Our reference: P-900106-Y8P3
Contact: Nick McMaster
Telephone: (02) 4732 8578

19 May 2025

Council Response to Environmental Impact Statement – SSD-70818708 – DHL Logistics Facility Badgerys Creek South at 1953-2109 Elizabeth Drive, Badgerys Creek, NSW, 2555

DATE ISSUED
10 OCTOBER 2024

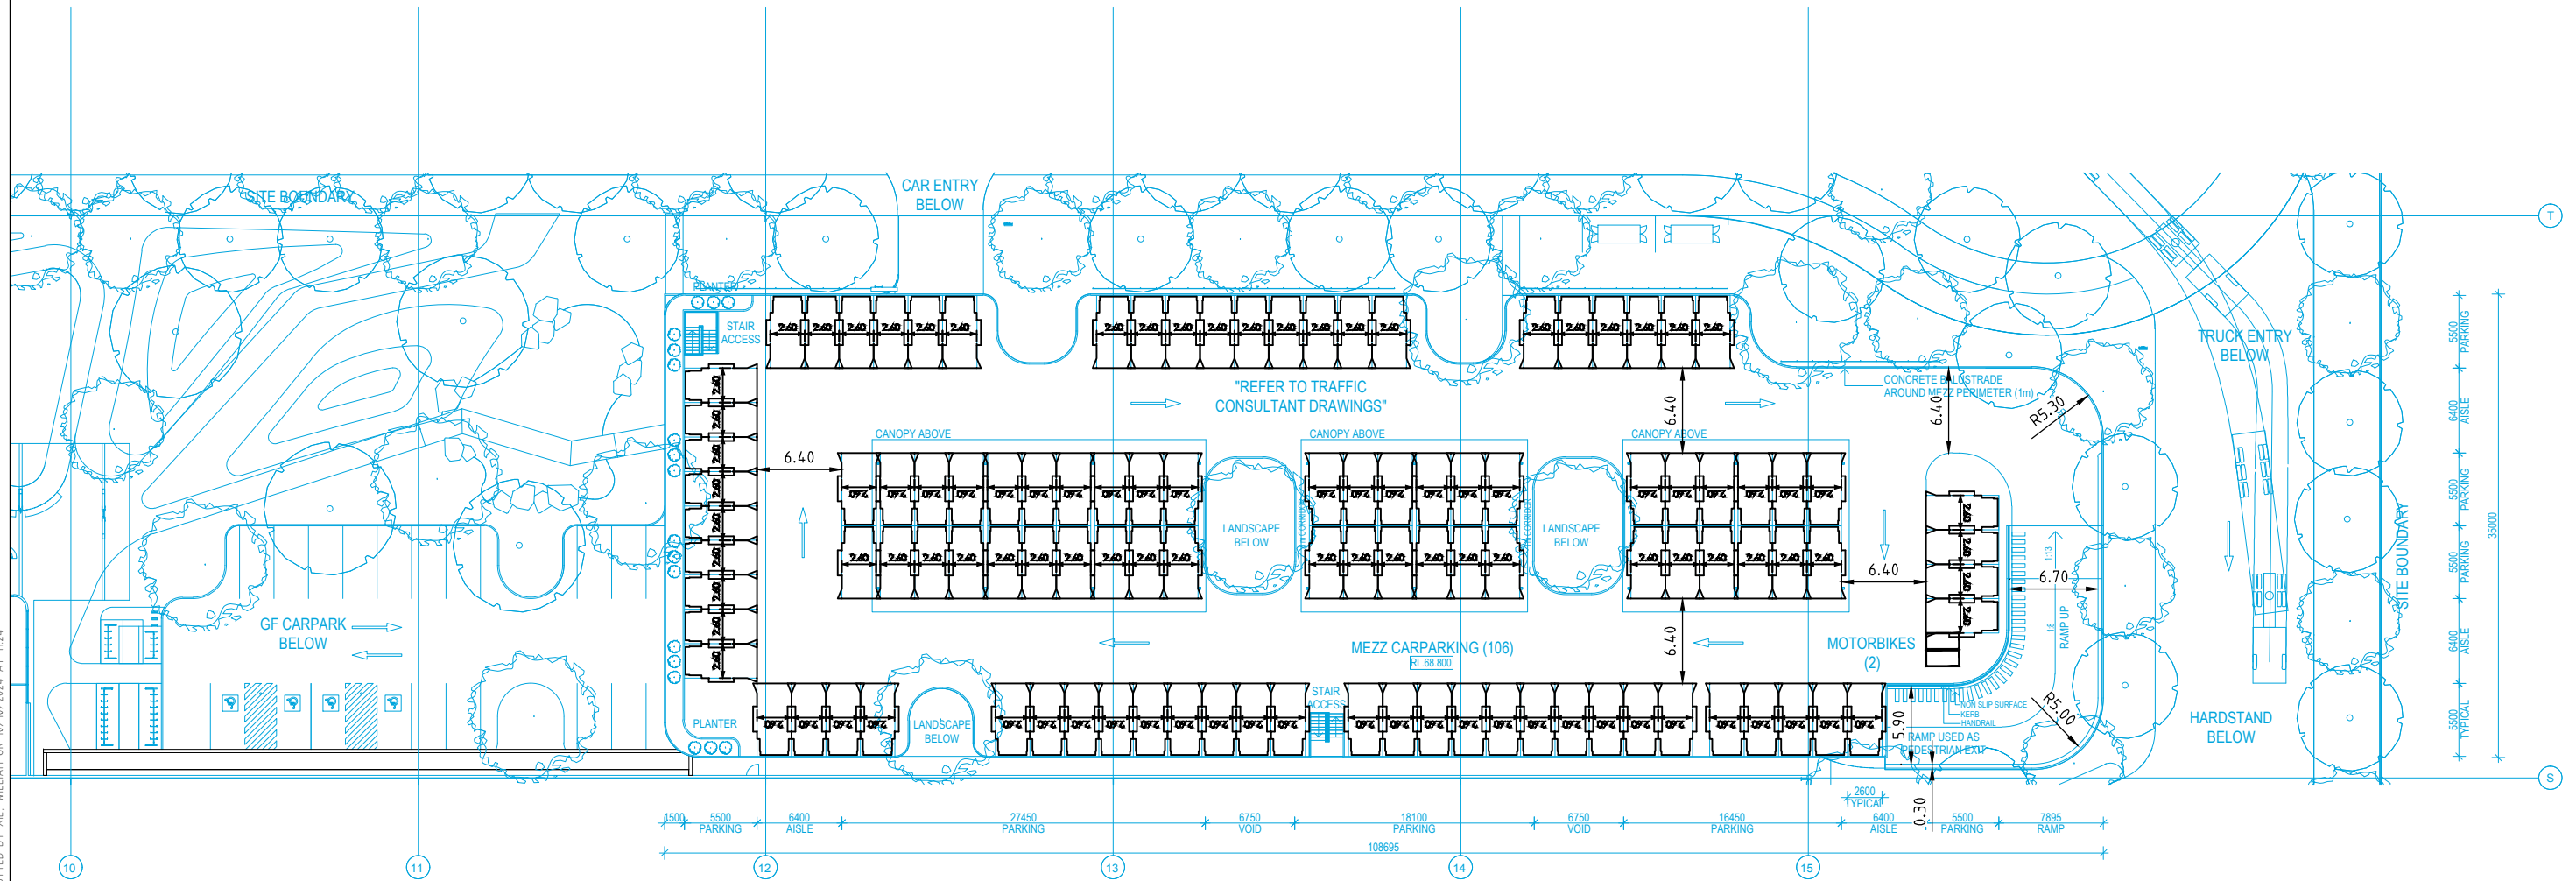
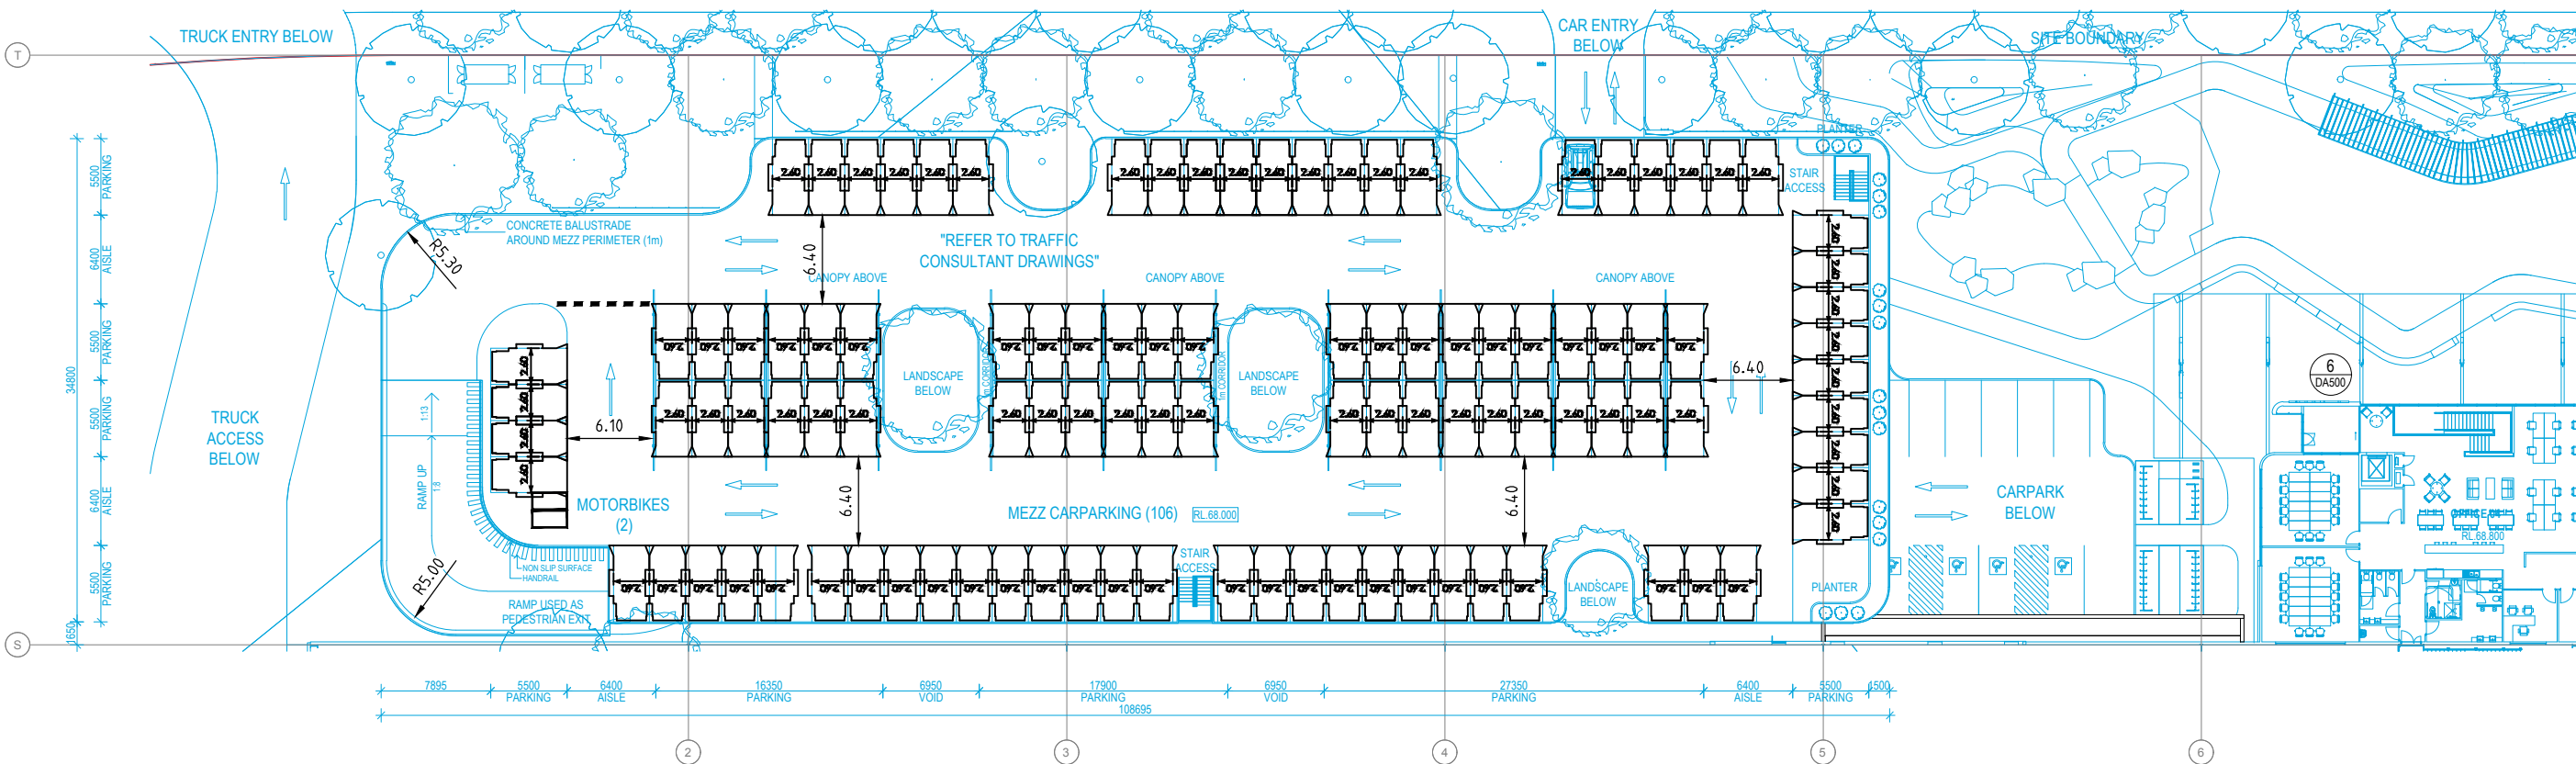
- a) Clarification is required regarding compliance of westernmost proposed truck exit with respect to its proximity to the adjacent intersection. No clear dimensions are given for assessment purposes regarding distance from the intersection.

- b) The architectural plans are not of sufficient detail (dimensions not provided for assessment purposes) to assess whether compliance with AS2890.2 has been demonstrated regarding all proposed truck entry/exit driveways.

- c) The architectural plans are not of sufficient detail (dimensions not provided for assessment purposes) to assess whether compliance with AS2890.1 has been demonstrated regarding car parking areas.

- e) Any internal driveway access gates/boom-gates/etc. must be positioned internally such that a full vehicle length (of the largest vehicle designated to use the corresponding entrance) can be accommodated wholly within the site and not queue on the public roadway. It is not clear from the application whether this has been achieved.
